Subject: RE: Planning Consultation on: FG/87/21/PL

Fire Safety

Application No: FG/87/21/PL
Registered: 19th May 2021
Site Address: Tudor Close Ferringham Lane Ferring BN12 5NQ
Grid Reference: 509239 101970
Description of Works: 1 No. new unit in roof space plus reconfiguration of approved dwellings & other changes including retention of flat roof extensions and new dormers to courtyard elevation (revised application further to permission granted under FG/105/20/PL). This site is in CIL Zone 4 (Zero Rated) as flat.

Drawing Title:
**First Floor Plan
As Proposed**

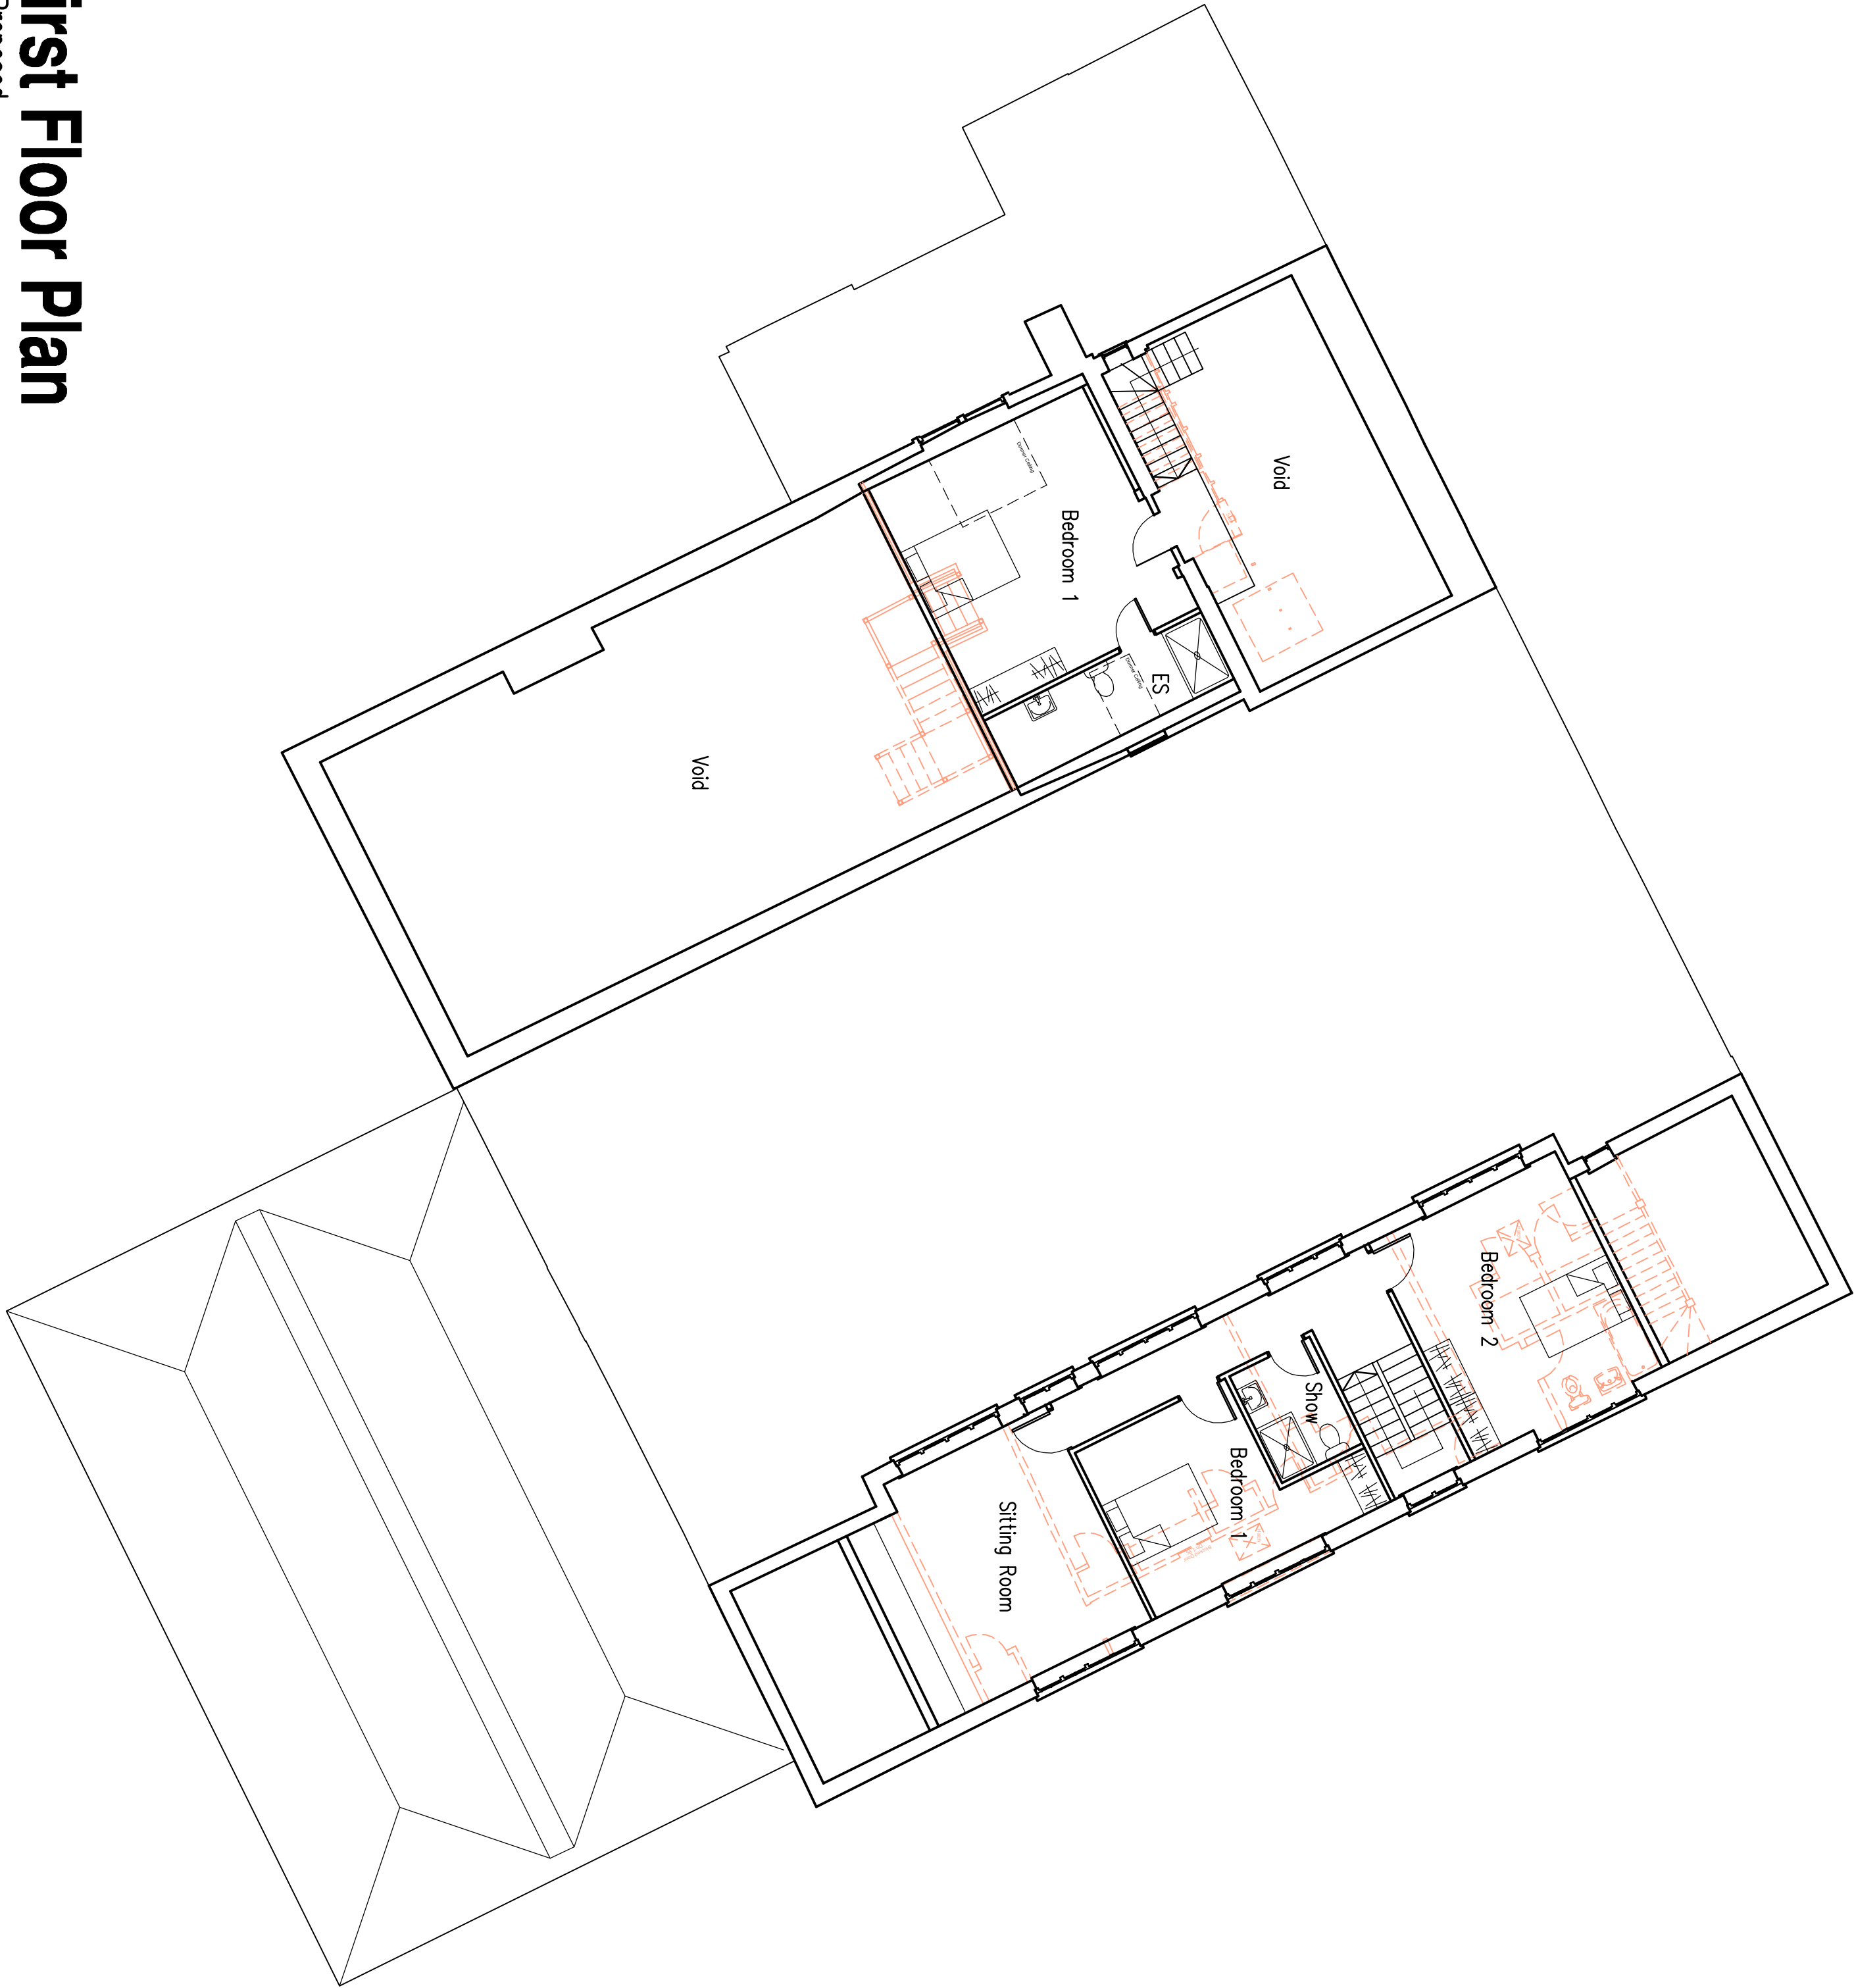
- Unit ? (first floor West facing) – egress is via two outer rooms which is not considered acceptable. Escape windows and Grade D1 interlinked smoke detection required to both bedrooms. N.B. If the criteria for an escape window cannot be met to either bedroom, the layout of this unit would require altering.

- Unit ? (first floor East facing) – egress from bedroom 2 is via the living room, making bedroom 2 an inner room. An escape window, FD30S fire door and Grade D1 interlinked smoke detection is required to the bedroom.
